SUBJECT: SFD1903-0009
SINGLE FAMILY DWELLING

To: H & H CONSTRUCTORS INC

Here are the results of all Inspections located at **321 NEW CASTLE LN:**

Inspection Type: ROUGH IN
Scheduled Date/Time: 8/19/2019
Completed Date/Time: 8/19/2019
Inspector: Scott Guy
Result: DISAPPROVED
Remarks: eTRAKiT Inspection Request
Notes: 8/15/2019 1:23 PM H & H CONSTRUCTORS INC

TITLE
 MAIN FLOOR PLAN
 STAIR SECTION

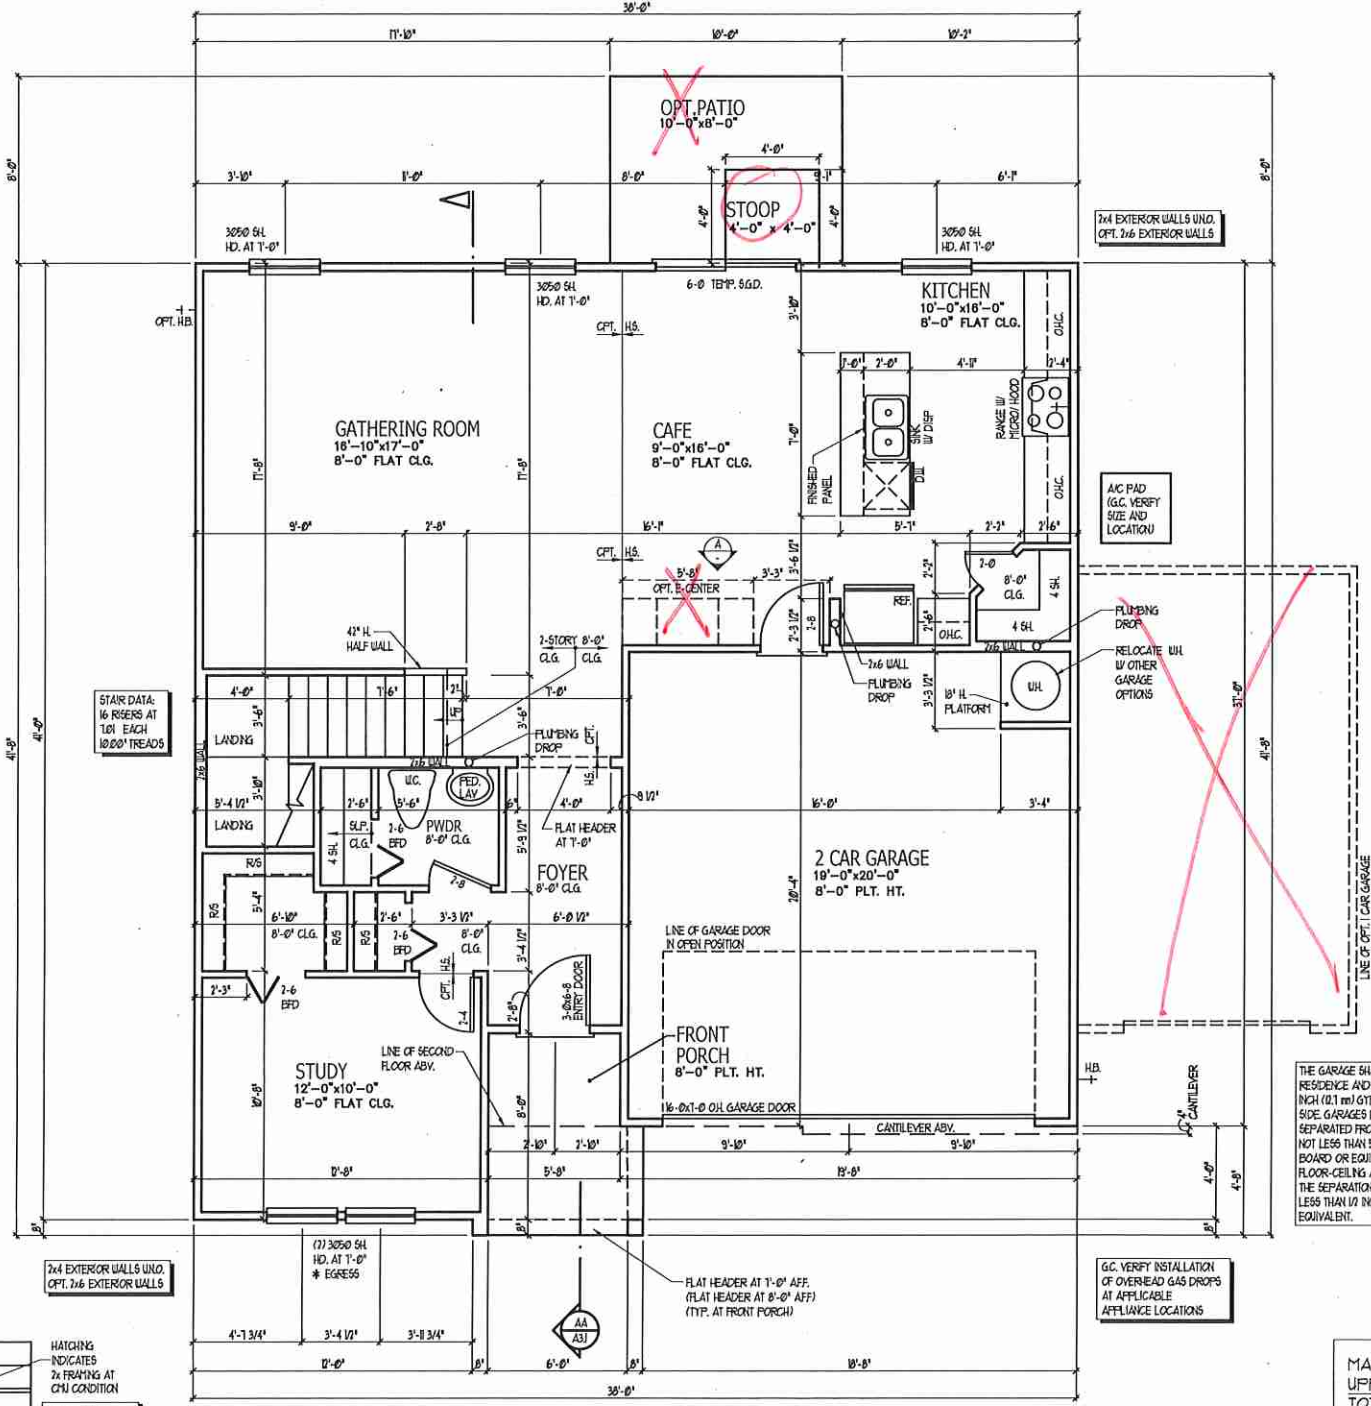
1-2" flat washers required at garage wing walls. 2-pack out walls at fridge and pantry for 3" pipe. 3-rear slider door requires 2 king studs each side. 4-attach toilet flange first floor. 5-attach interior loadbearing walls. 6-frame around second floor duct chase. Ok to insulate and side.'
